Our ref: DOC21/629824-57

Your ref: SSI-7319

M1 Pacific Motorway extension to Raymond Terrace (SSI-7319) – review of EIS

BCD has reviewed the Environmental Impact Statement, including relevant appendices, in relation to impacts on biodiversity (including matters of national environmental significance [MNES] under the *Environment Protection and Biodiversity Conservation Act 1999*) and flood risk.

Figure 3-1: PCT 1747 Grey Mangrove low closed forest locations

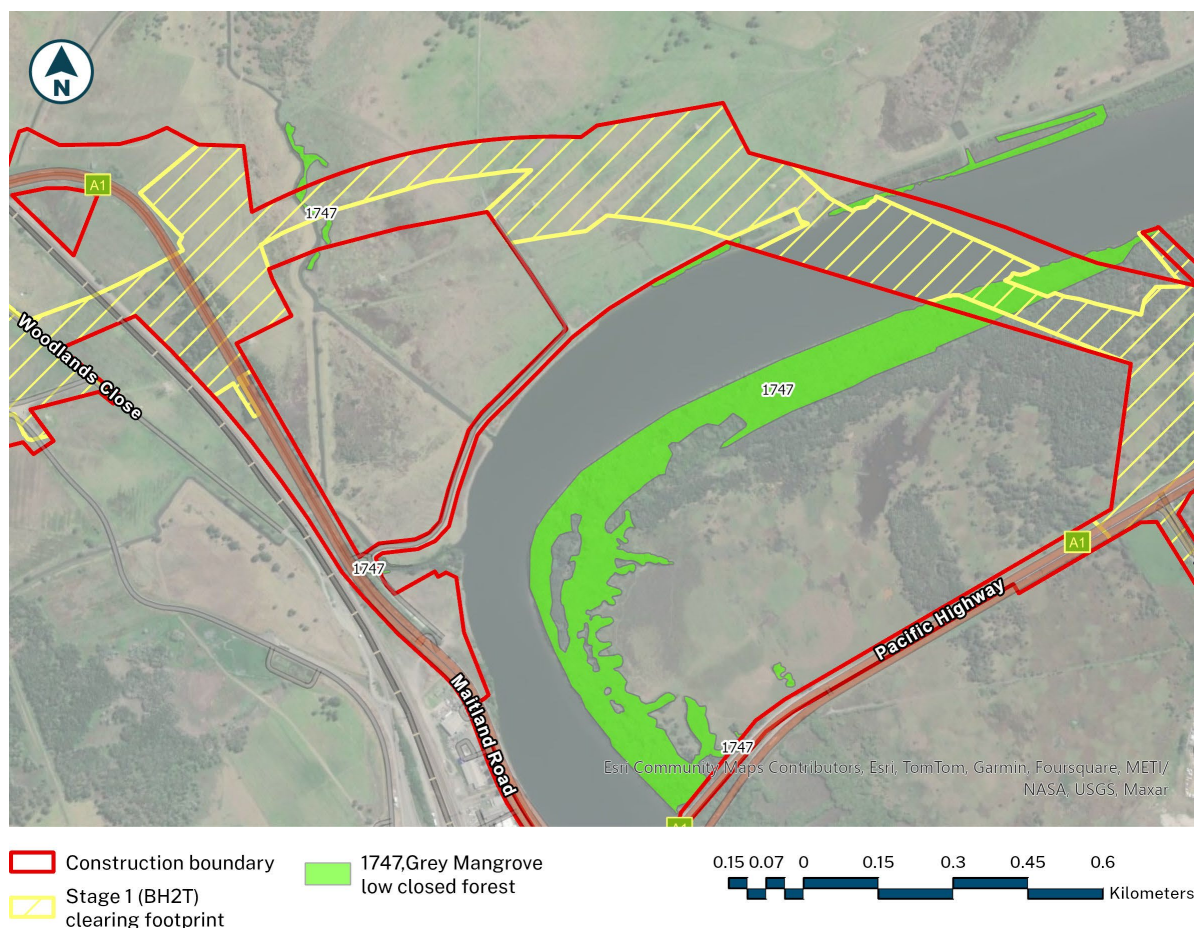
- Black-tailed godwit – known from the Hunter Estuary and surrounds with various records in the Hunter Sub IBRA, within 5km at Hexham Swamp (recorded in 2002 and 2012); and suitable habitat present on the development footprint: - open saline mudflats and semi-tidal saline muds (Plant Community Type [PCT] 1746 – *Saltmarsh Estuarine complex*: 1.26 hectares (ha)) and tidal muds (PCT 1747 – *Grey Mangrove low closed forest*: 2.27 ha).

- Terek sandpiper - known from the Hunter Estuary and surrounds with various records in the Hunter Sub IBRA, at Hexham Swamp (recorded in 2006); and suitable habitat present on the development footprint: - intertidal mudflats (Plant Community Type [PCT] 1746 – *Saltmarsh Estuarine complex*: 1.26 ha) and mangroves (PCT 1747 – *Grey Mangrove low closed forest*: 2.27 ha).
